An Coimisiún Pleanála - Case reference: PAX91.323780

Re: Objection to the Proposed Ballinlee Wind Farm Development

Planning Submission: Objection to the Proposed Ballinlee Wind Farm Development

Project: Ballinlee Wind Farm

Figure 12-6: Zone of Theoretical Visibility Map (ZTV) – Tip Height

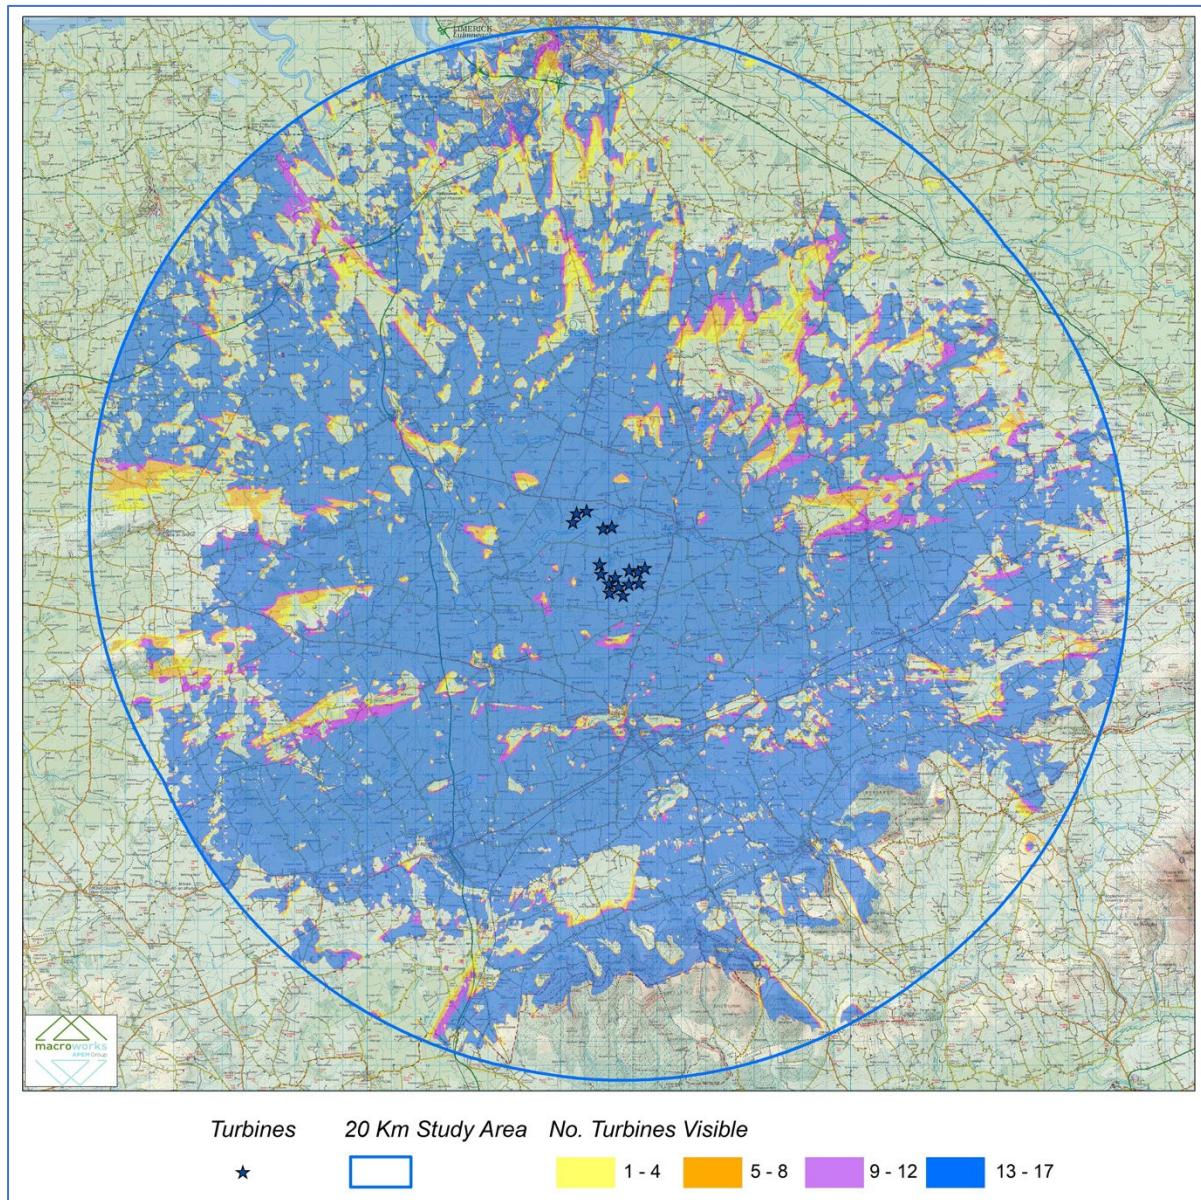
No complete ZTV is presented to establish the geographic extent of theoretical visibility across Bruff and its environs. Without this, the claim that effects "vary in degree and significance" is unsubstantiated and contrary to WEDG (2006) and GLVIA3 methodology. The submitted photography is incomplete, particularly for the northwest (NW) sector.

Given Bruff's compact form in a relatively open landscape, ~~to~~ visibility for tall turbines is typically indicated by ZTV. Omission of settlement scale assessment under "Population and Human Health" (including potential relationships between visual dominance, annoyance, and quality of life) is inconsistent with the Directive and EPA guidance. The effects mapping presented is partial and may mislead nonspecialists.

Without complete ZTV mapping and verified visualisations, the EIAR does not meet Annex-B(1)(d) or EPA (2022) transparency requirements. Settlement scale receptors (Bruff) must be assessed; the omission undermines conclusions on visual stress/amenity.
